From: Chris Pirone
To: Jean Fraser
Date: 8/14/2014 8:02 AM
Subject: Re: is this cond of approval satisfied re 421 Warren

i. That the applicant shall address the Fire Prevention concerns, as outlined in the e-mail from Captain Chris Pirone of the Fire Department dated April 30, 2014, to the satisfaction of the Fire Department; and

Initial Fire Comments:

REV	DATE	DESCRIPTION	REVISIONS
3	07.03.14	FINAL PLAN SUBMISSION TO CITY PER CONDITIONS OF APPROVAL	
2	04.17.14	FINAL PLAN SUBMISSION TO CITY	
1	02.10.14	SUBMITTED TO CITY OF PORTLAND

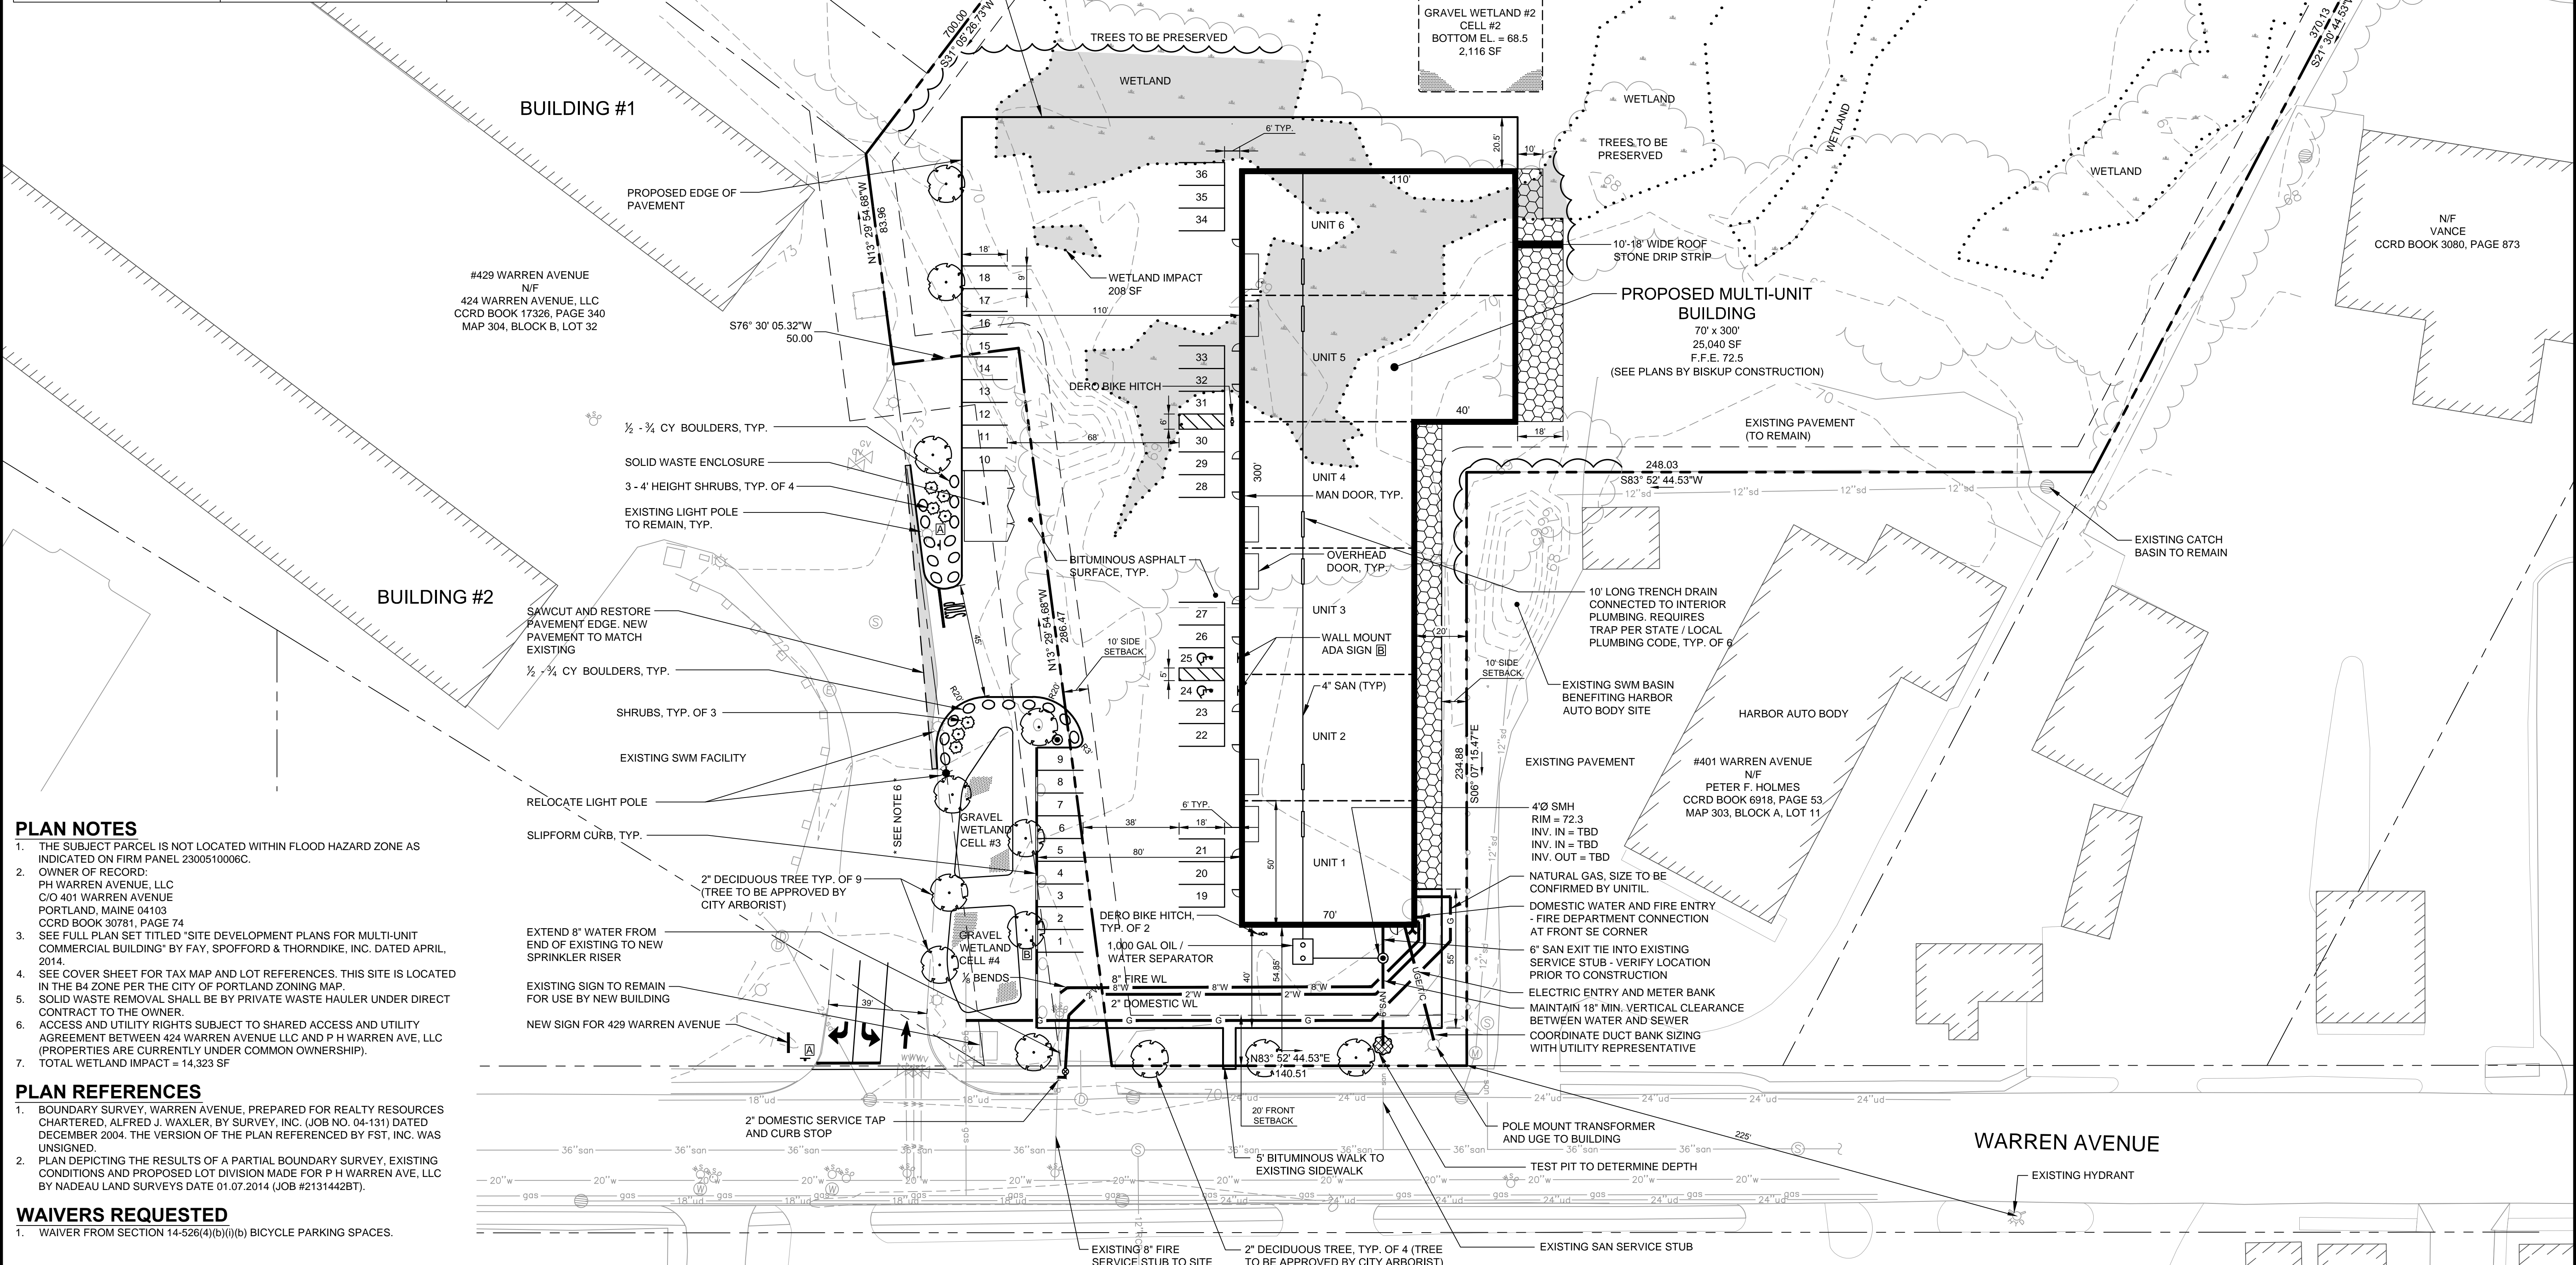
Access looks good as aisle widths are presently 38'.

Is the 20' access at the rear of the building being proposed for the Fire Department?

The fire department connection for the sprinkler system will need to be located on the front of the building and will need to have a fire hydrant within 100' of the connection but no closer than 40'.

Has an NFPA 1 code analysis been performed for the site?

A private fire hydrant may need to be installed per NFPA 1 on site.

Identification of the building shall have the address at the entrance and on the building which each unit being identified by Suite and letter such as 421 Warren Ave. Suite A.

Exits from the building shall continue from the building onto the site with clear walkways for the occupants to stage if an emergency happens in the building.

We spoke about it at a Dev Rev about a month ago when you confirmed they needed another hydrant- and they have added a hydrant to the site plan (see attached) - but is all else OK from a site plan viewpoint?

Fire is all set.
